Together Against Sizewell C

Deadline 10 Submission TASC IP no. 20026424

TASC comments on document 9.13 REP8-096 submitted at deadline 8 and related issues connected with SZC's coastal defences

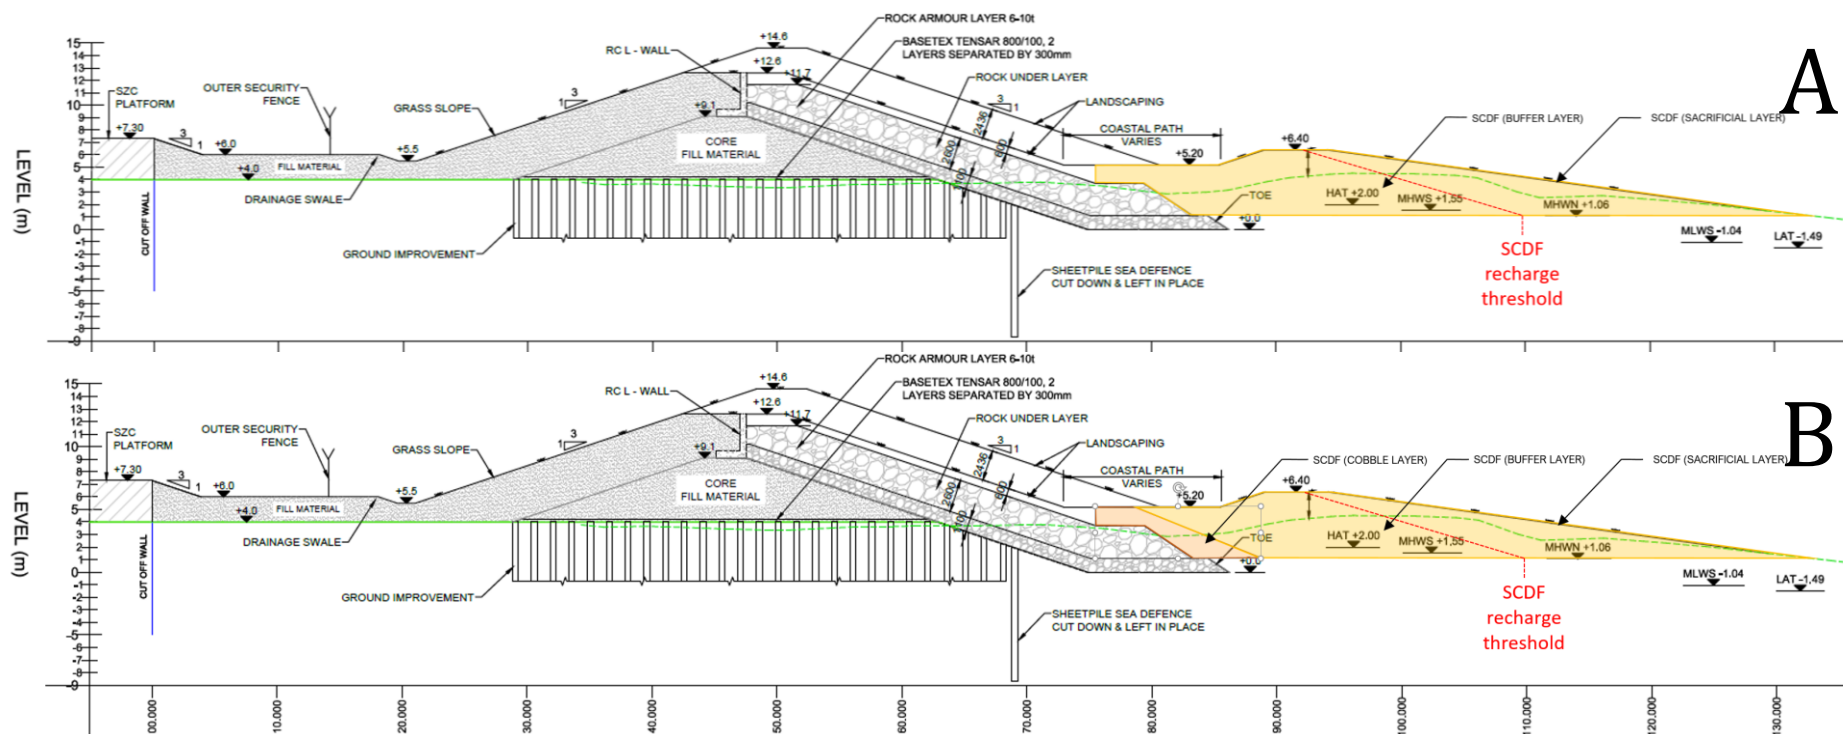
Sea Defence Designs- TASC are concerned that the sea defence designs have been delivered so late in this process that proper scrutiny by IPs is not possible. TASC have concerns that the toe of the HCDF would likely need to be adapted within the lifetime of the project, so are dubious as to why the Applicant is not proposing a more robust design at this stage.
